Letter of Intent for Application for Special Use Permit

# Monument Glamping El Paso County, Colorado

PCD File No. AL-22-003  
Originally Prepared: March 16, 2022  
Review Addenda: May 9, 2022

MONUMENT GLAMPING SITE PLAN
16315 RICKENBACKER AVE.
MONUMENT, CO 80132

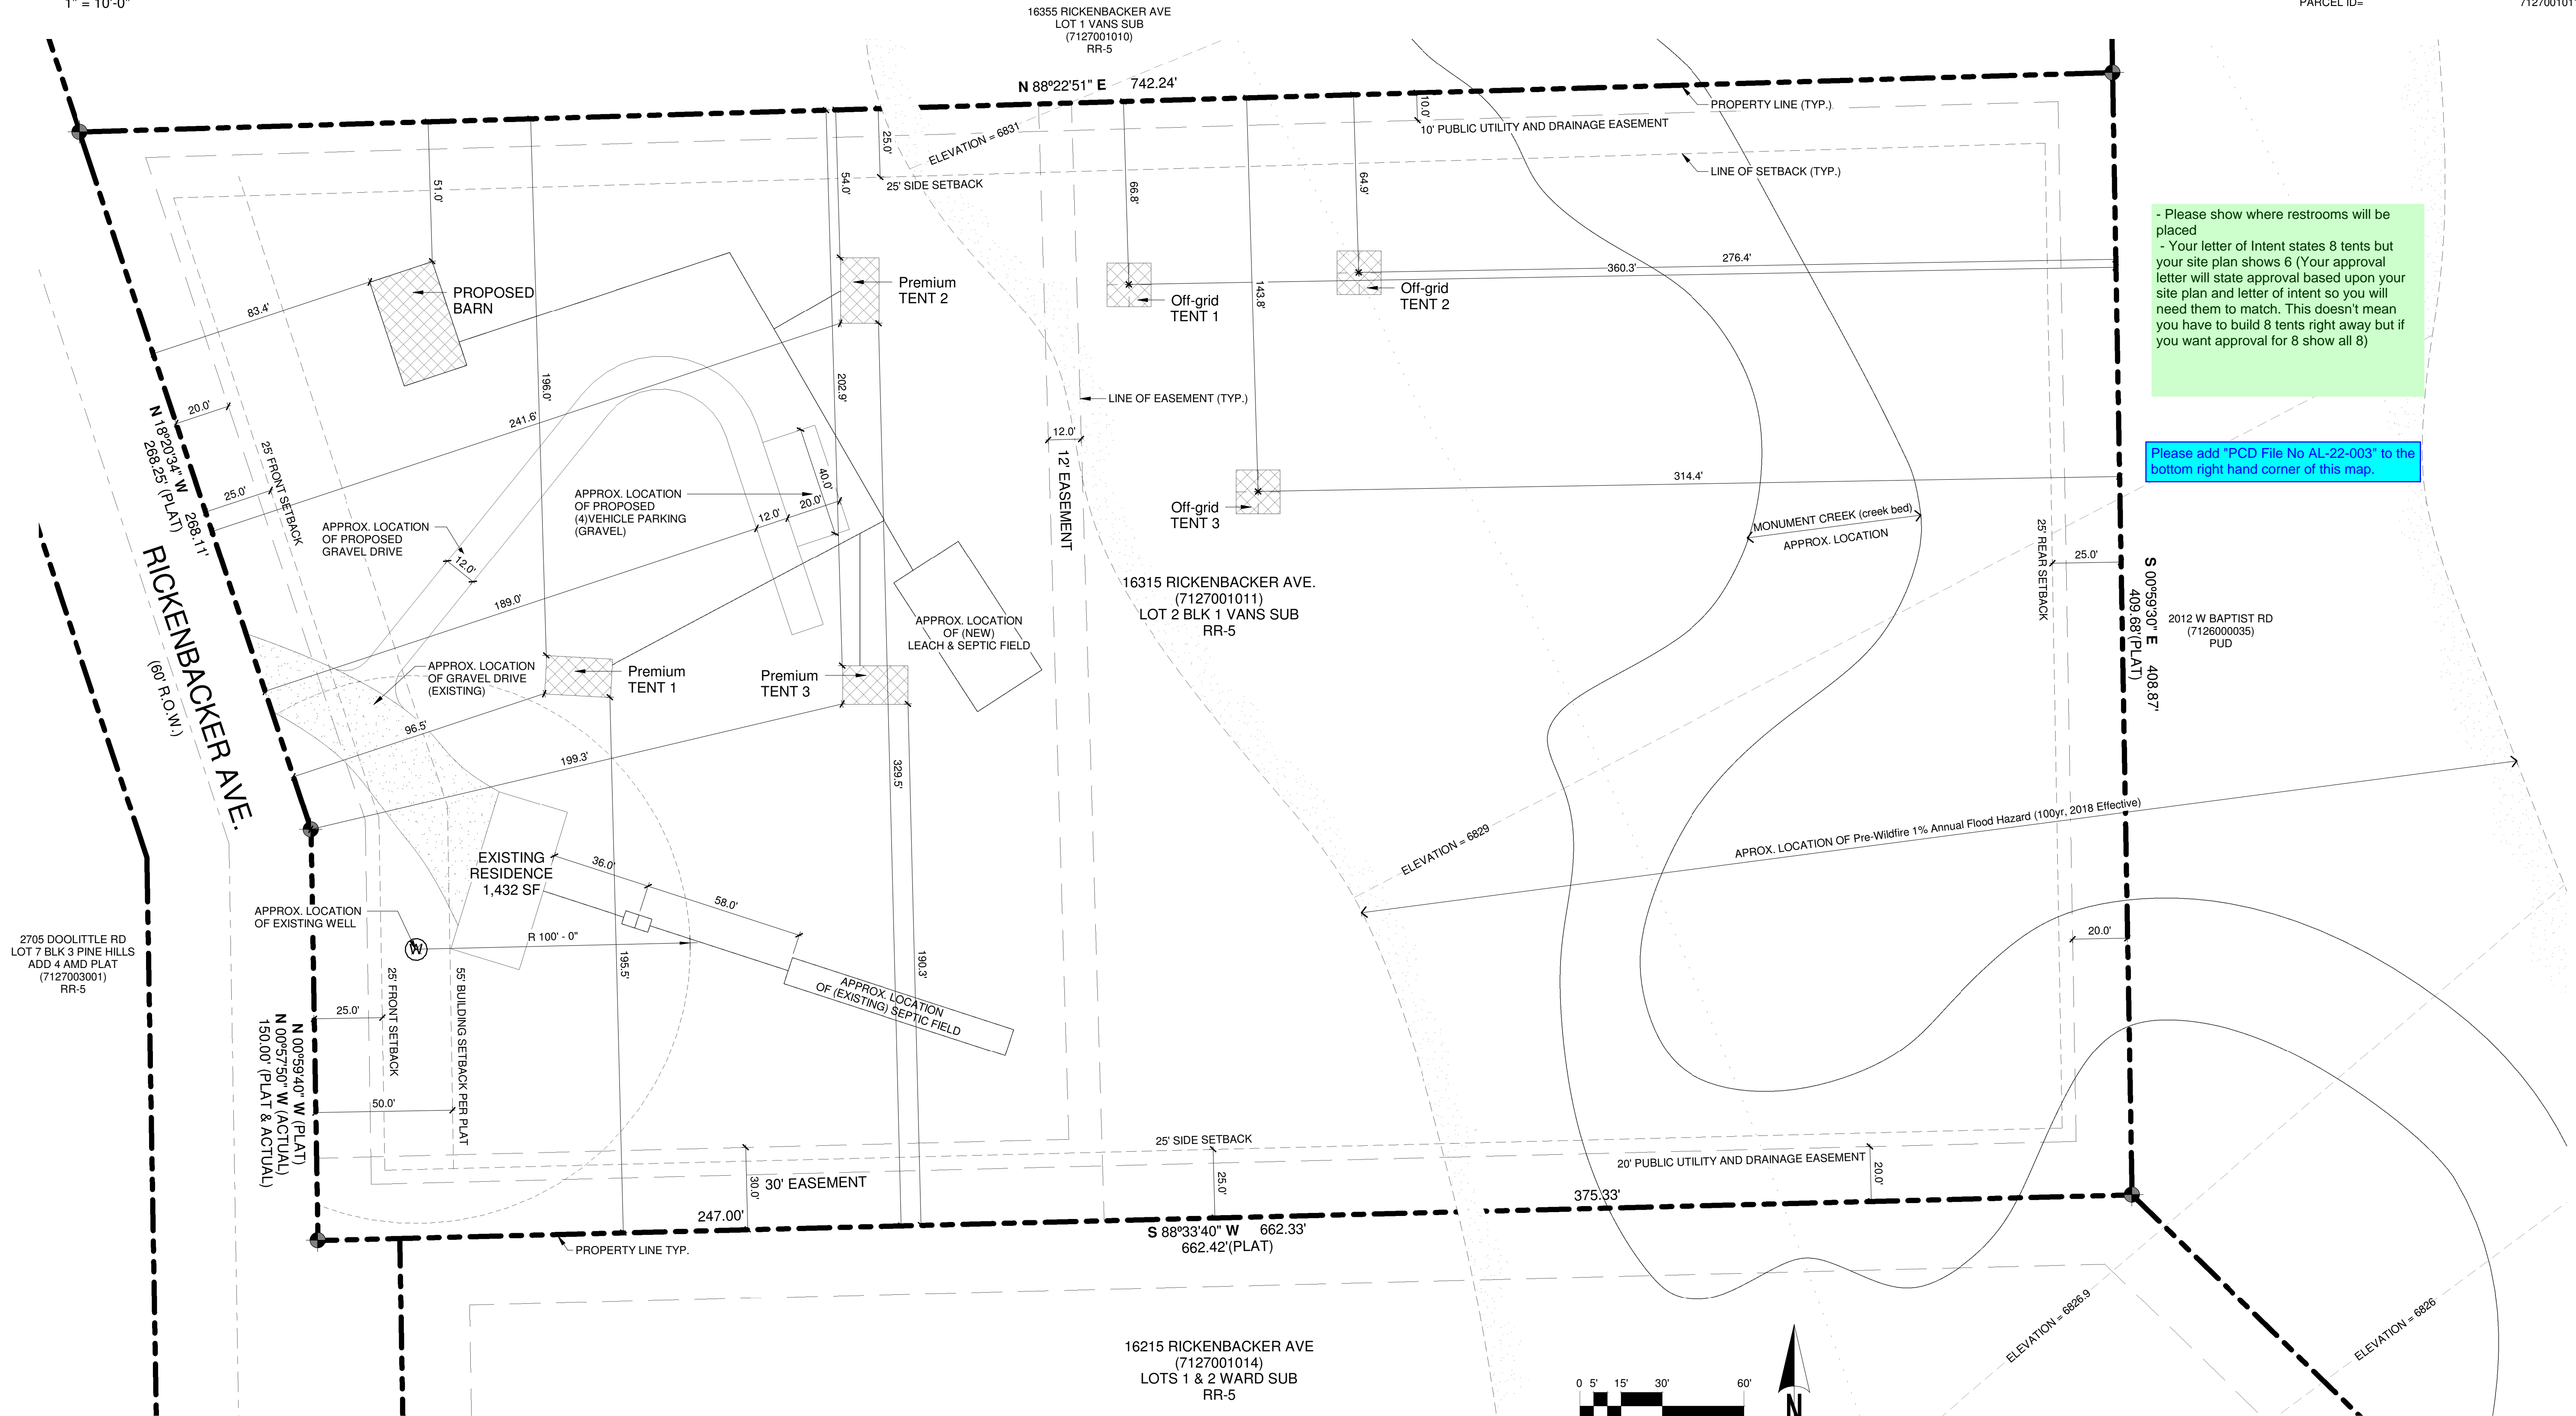
**Clarification 6/11/22 per County Review: "Explain how each site will have its own bathroom. Is it in the tent?"** The Premium Site bathrooms will resemble a simple outhouse and will be located outside the tent by the single parking spot. These small structures will have a flushable toilet, a single shower, and a sink. The site development plan goes into more detail with this simple sketch (see right) of how each Premium Site will lay out.

**Addended 5/5/22 for clarity after meeting with a neighbor:** For the sake of this development, our glamping "units" will consist of "premium" sites and "off-grid" sites. For the sake of this Special Use, every "unit" is recognized as a single dwelling unit with water and septic limitations as engineered by code. This Special Use is capped at 8 units (the maximum dwellings allowed with the new septic system), and our Site Development is building only 6 units (3 premium sites and 3 off-grid sites). **Clarified 6/11/22 per County Review:** The new site map contains all 8 sites.

See the Monument Glamping Site Development Plan (following the Monument Glamping Special Use Permit) for details. **Added 6/18/22 per County Review:** See Proposed Footprints for more specific layout of each Premium Site, particularly how the bathrooms are included.
